May 2, 2024

**Re: Event Center
1611 Airtech Ct SE
Site Plan
Architect's Stamp -no date- not for construction (N15D017)**

Based upon the information provided in your submittal received 4-16-24, the above referenced plan cannot be approved for Building Permit until the following comments are addressed:

DATE	3/29/2024	SHEET	G3A
SCALE:

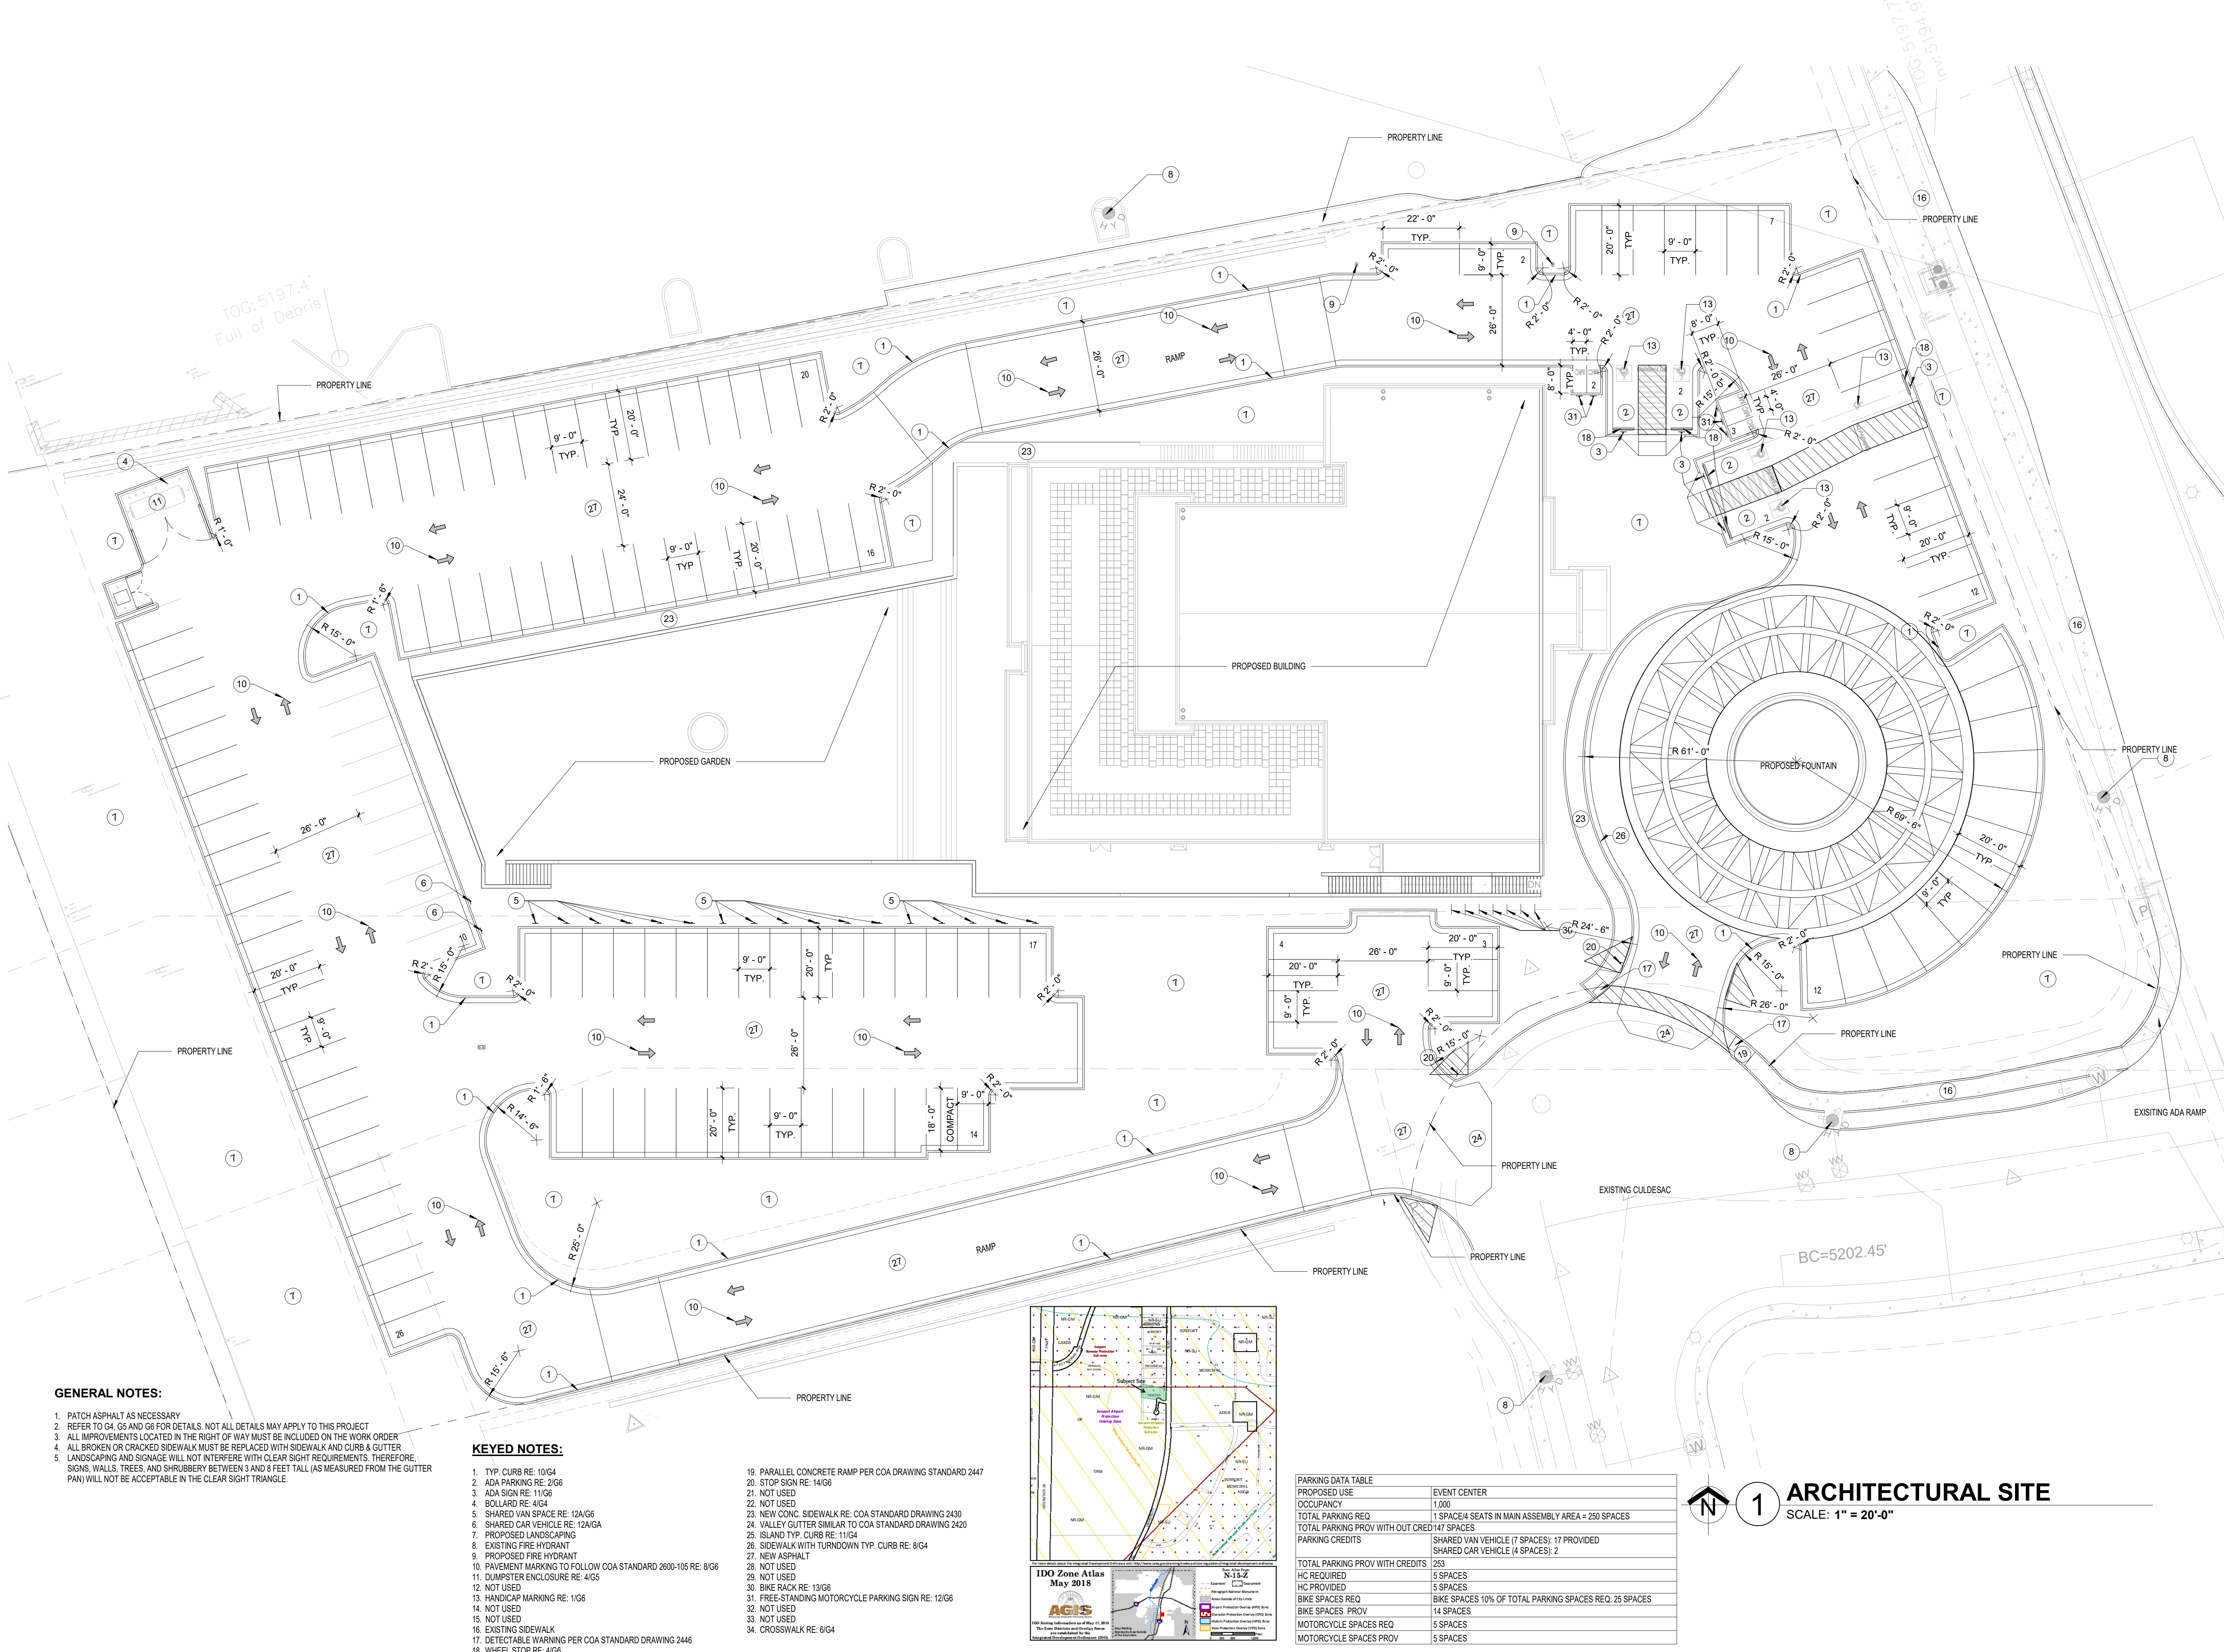
1. There should be 8 accessible parking spaces when the total number of parking spaces provided is 101-300 (2015 NM Accessible Parking Checklist). In addition, 2 van spaces should be provided. Revise the parking table as necessary, add three more accessible parking spaces and show which 2 accessible spaces will be designated as the Van Accessible spaces.

2. Where are the Shared Car Vehicle spaces?
3. The two "Compact" spaces should have "COMPACT" pavement markings in the rear of the space.
4. Show the drainage inlet on the plan that is located in the west/northwest area of the cul-de-sac. The gutter transition begins 5' on either side of the inlet. It appears you may have to relocate the inlet, if approved by Hydrology. This will require a drainage submittal to Hydrology and a Work Order for the relocation. It may also require reconstructing the cul-de-sac to change the low point to the new inlet location.

5. There is a patterned surface around the fountain, which appears to be where vehicles will drive. Provide: material, width of driving surface and inside radius.

6. The patterned surface in comment #2 above, overlaps the curb and gutter in a few places. Probably should reduce the diameter of the patterned surface.

7. Is there a curb or similar (e.g. apron) to prevent drivers from crashing into the fountain?
8. Provide the width of the drop-off lane on the west side of the patterned surface.

9. Please label the front door/main entrance.
10. Provide/show the 6' accessible path from a ROW to the building.
11. The sidewalk and landscape area appear to merge at the building entrance and there is no accessible path from the accessible spaces to the front door.

12. What are the slopes of the “ramps” on the north and south sides of the building. Max is 5%. I noticed the site drops approx. 30 ft from the cul-de-sac to near the west property line.

13. Do the perpendicular lines cross the ramps at the east and west end indicate change in slope? It would help with visibility if the south ramp flattened 50 ft or so from the flowline in the cul-de-sac.

14. It appears you have the 5' minimum keyway distance in the small parking lot south of the building. Please add a dimension.
15. The mini clear sight triangles are drawn too far from the back of sidewalk at the east entrance.

16. Show the existing sidewalk, Keyed Note 16, between the proposed entrances.
17. Provide dimensions for the spacing between the bike racks as well as the distance from the building. A bicycle parking space is 2'x6' (4' between racks) with a 1' clear zone around the perimeter of the bike racks. A detail may be helpful.

18. The proposed western entrance will need ramps on either side of it and please draw the proposed valley gutter.
19. In Detail 11 Sht G6, the bottom of the lowest sign (e.g. “Van Accessible”) is to be 60”/5’.

21. General Note 3. Improvements in the ROW will not be done on a Work Order, unless the inlet is to be relocated. In general, rather than a general note for this purpose, I’ve found it more helpful to include the “Work Order” language in the build note: e.g. Pave Alley by Work Order” or similar. I’ll attach a document that shows when a Work Order is necessary.
